WEST SUSSEX COUNTY COUNCIL CONSULTATION

TO:	Arun District Council FAO: Simon Davis
FROM:	WSCC - Highways Authority
DATE:	19 May 2021
LOCATION:	Land At Wings Nursery Lidsey Road Woodgate PO20 3SU
SUBJECT:	AL/20/21/PL Demolition of Wings House & erection of 71 No. replacement dwellings (70 net new dwellings), access arrangements, sustainable drainage measures, public open space, landscaping & all other associated works (resubmission following AL/46/20/PL). This application is a Departure from the Development Plan. New Technical Note received.
DATE OF SITE VISIT:	n/a (visited as part of the assessment undertaken for previous proposals AL/117/17/OUT, AL/32/19/OUT and AL/46/20/PL).
RECOMMENDATION:	More Information Required/Modification Required
S106 CONTRIBUTION TOTAL:	TBA

This is the second WSCC Highways (CHA) response to the above planning application for demolition of Wings House & erection of 71 No. replacement dwellings (70 net new dwellings), access arrangements, sustainable drainage measures, public open space, landscaping & all other associated works (resubmission following AL/46/20/PL).

This response follows consideration of latest Technical Note produced by Bright Plan Tran

Drawing No.
2019-6115-002

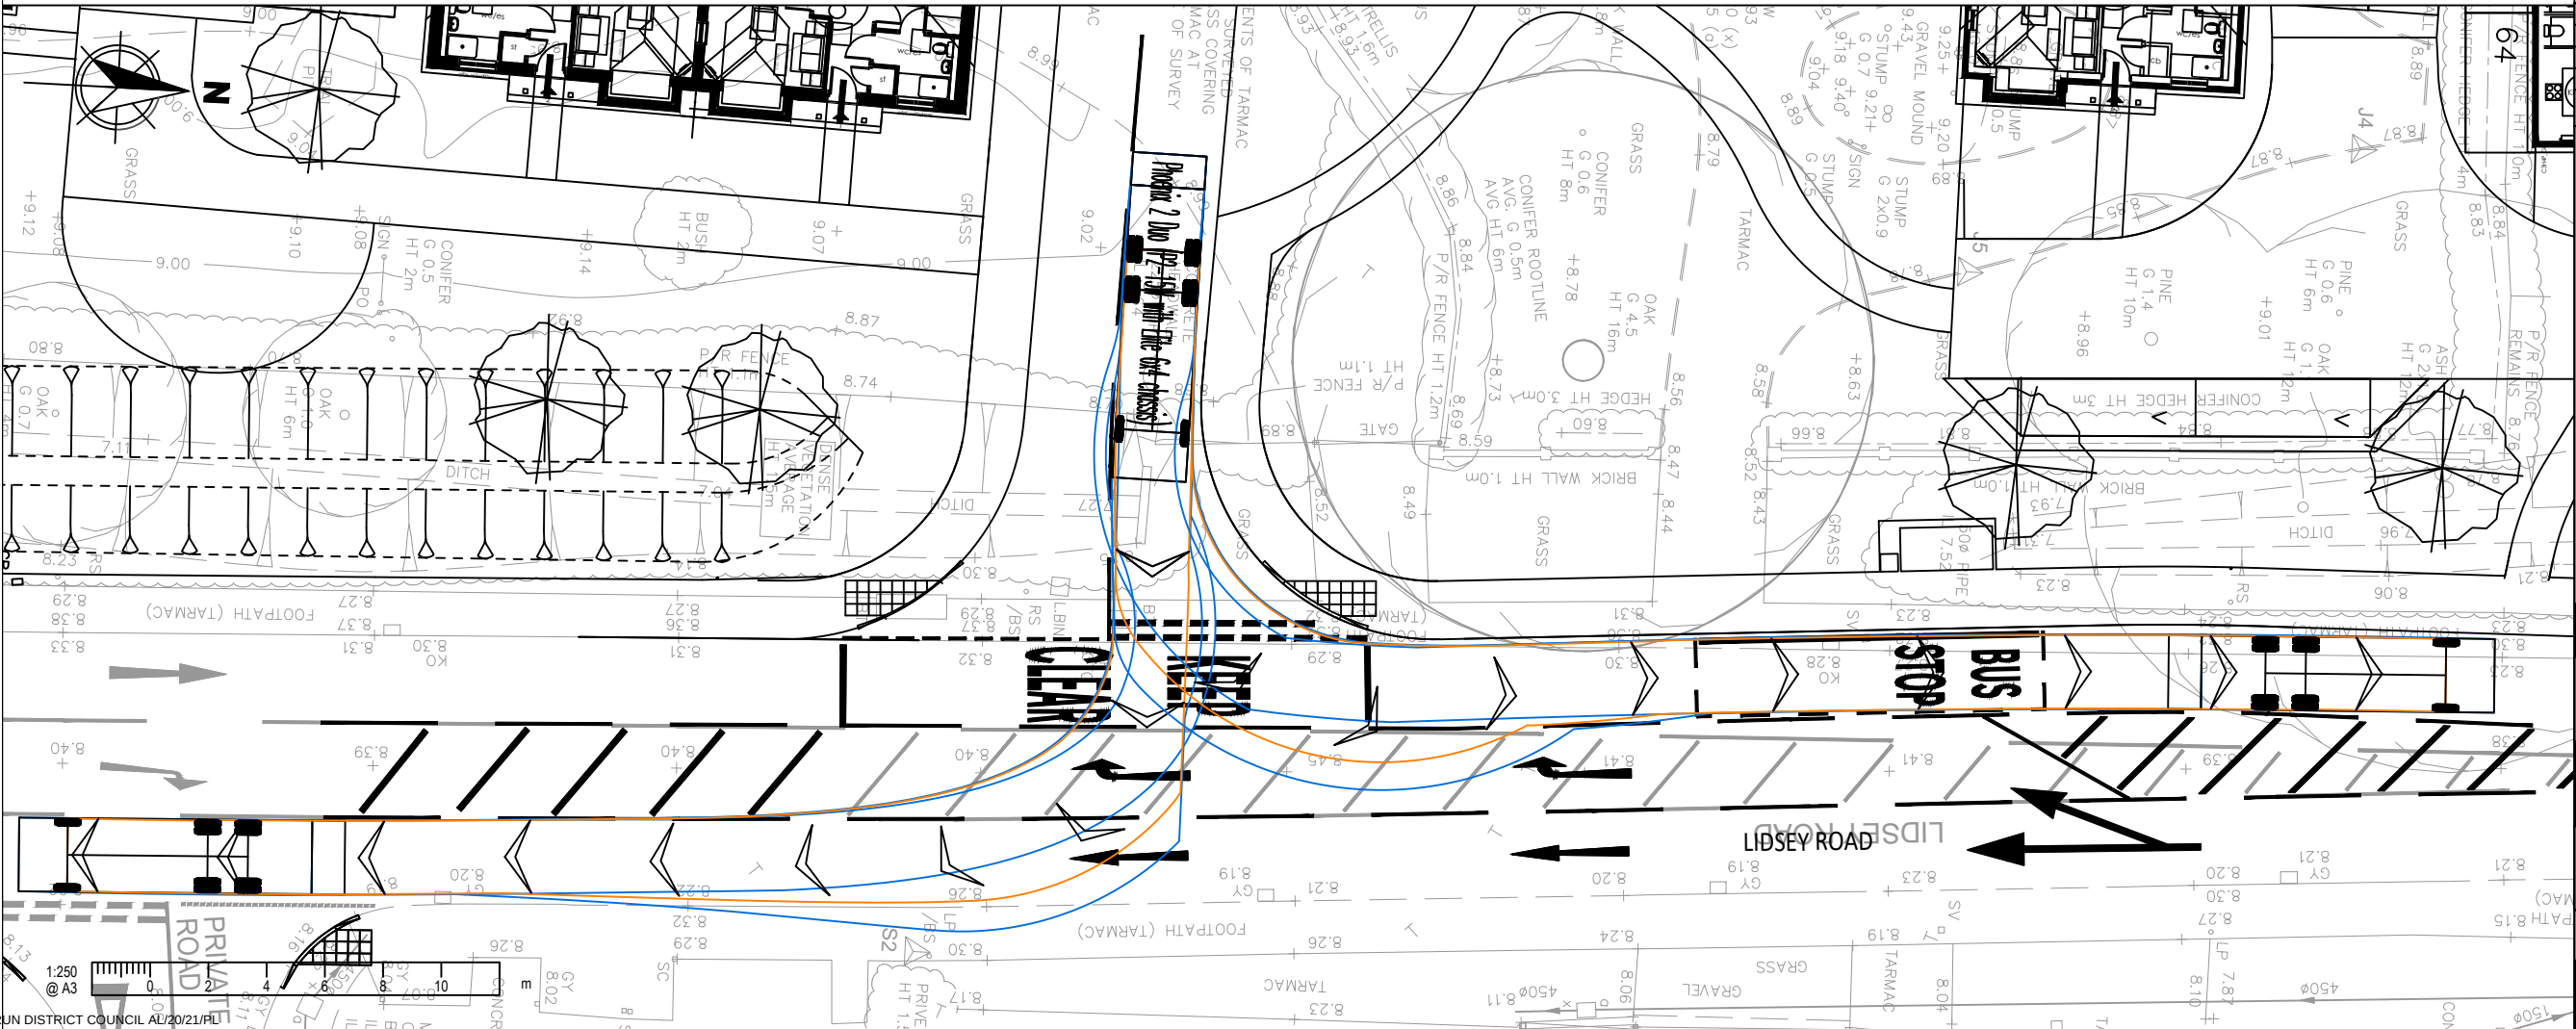
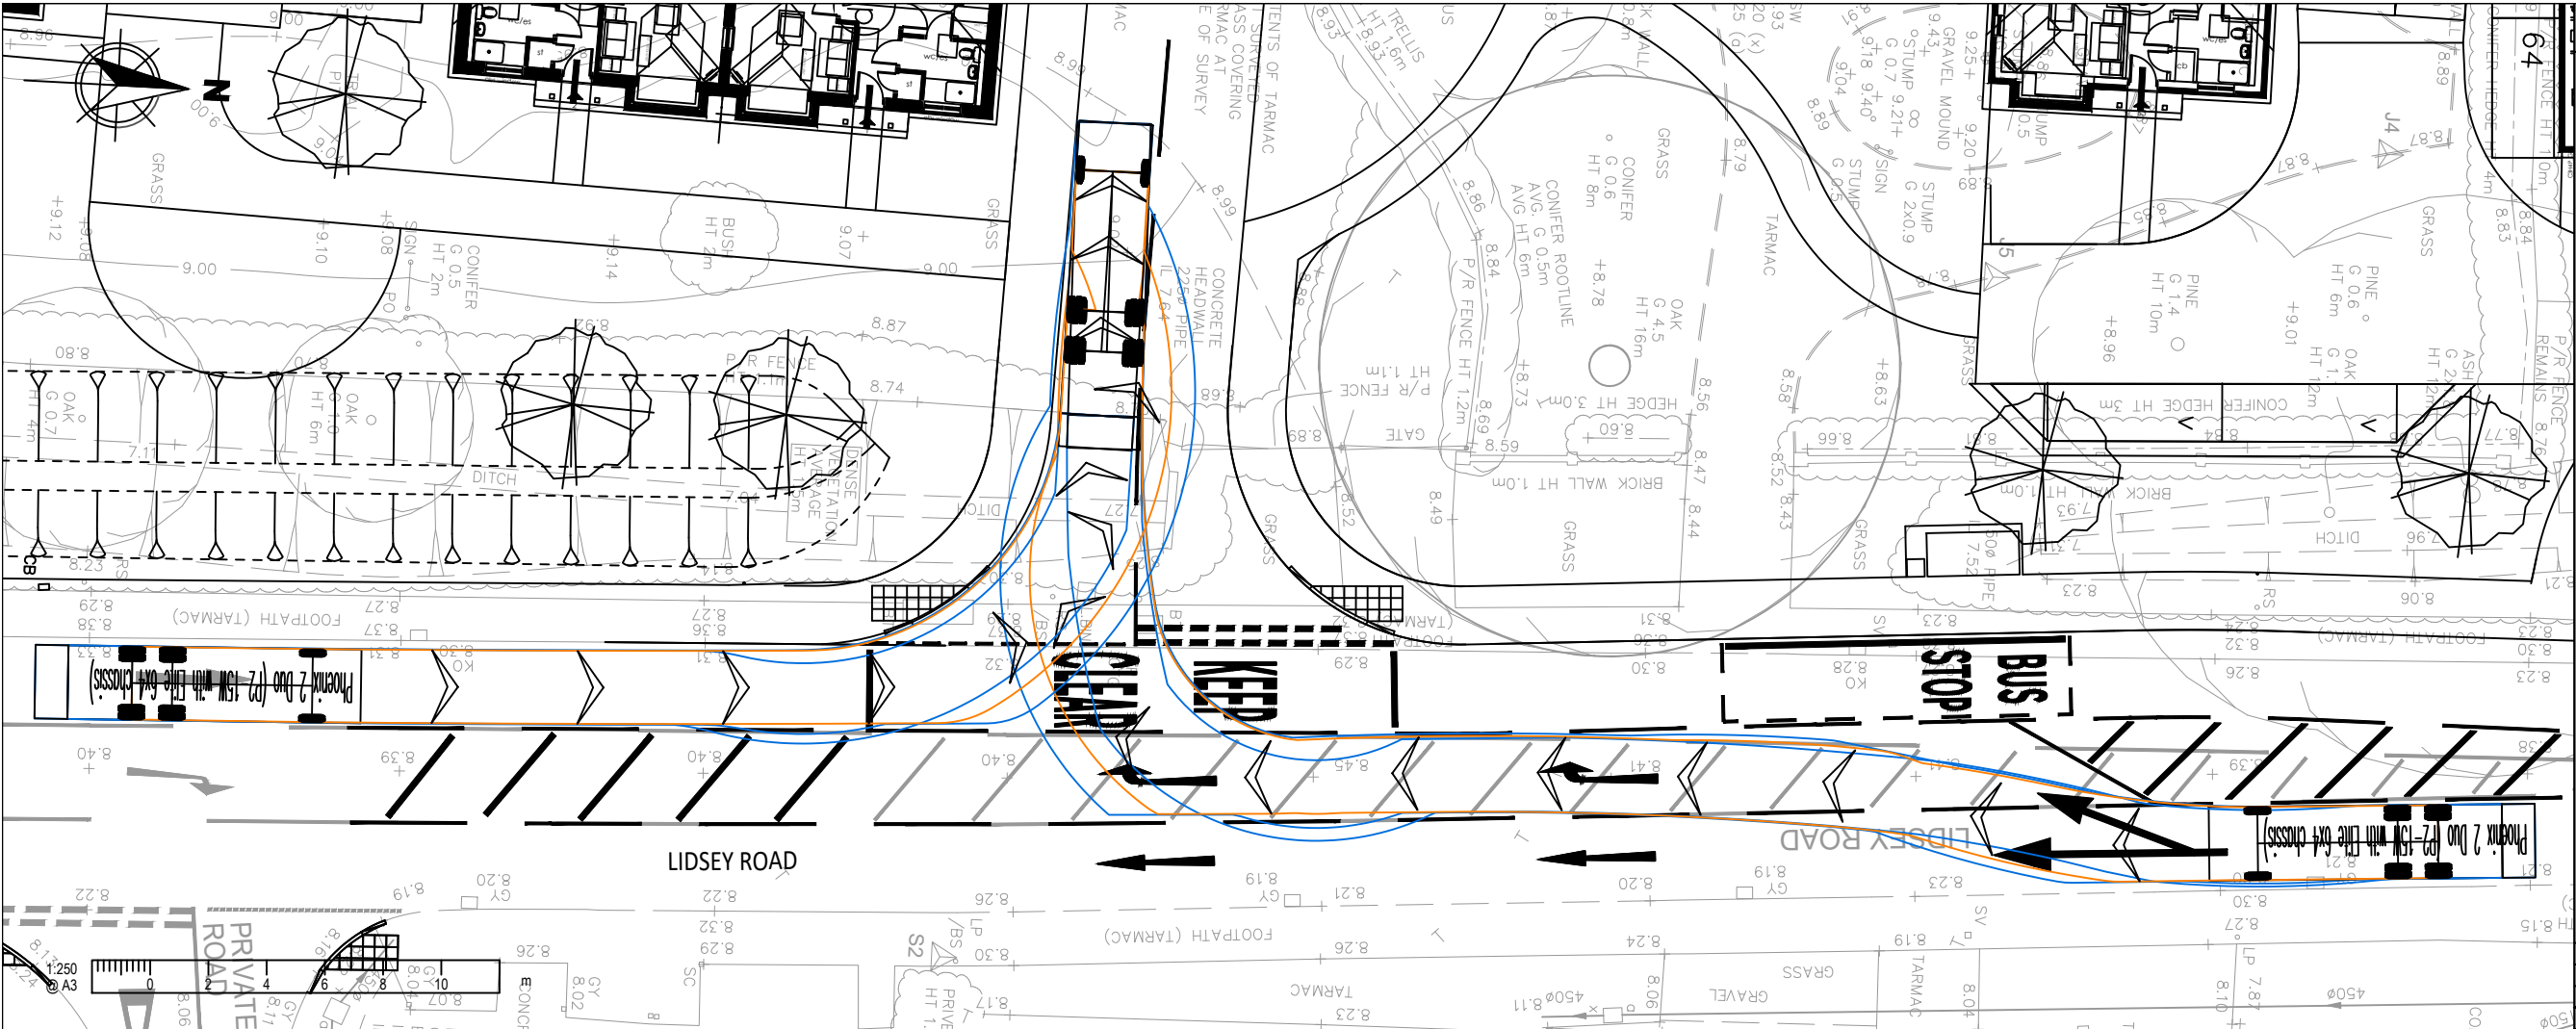
1. Tracking diagram for a refuse vehicle adjacent to plots 63 and 64. *The reply from the consultants says that refuse collection for these units would be undertaken from Lidsey Road as per existing properties in the locale. They consider that bin carry-distances for refuse collectors and residents are compliant with Manual for*

Streets as demonstrated in Drawing 2020-6115-008. While this might be the case, in practice the refuse contractor might choose to enter the access 'road' serving those houses. Therefore, the case officer should check with the provider to establish what their method of operation would be.
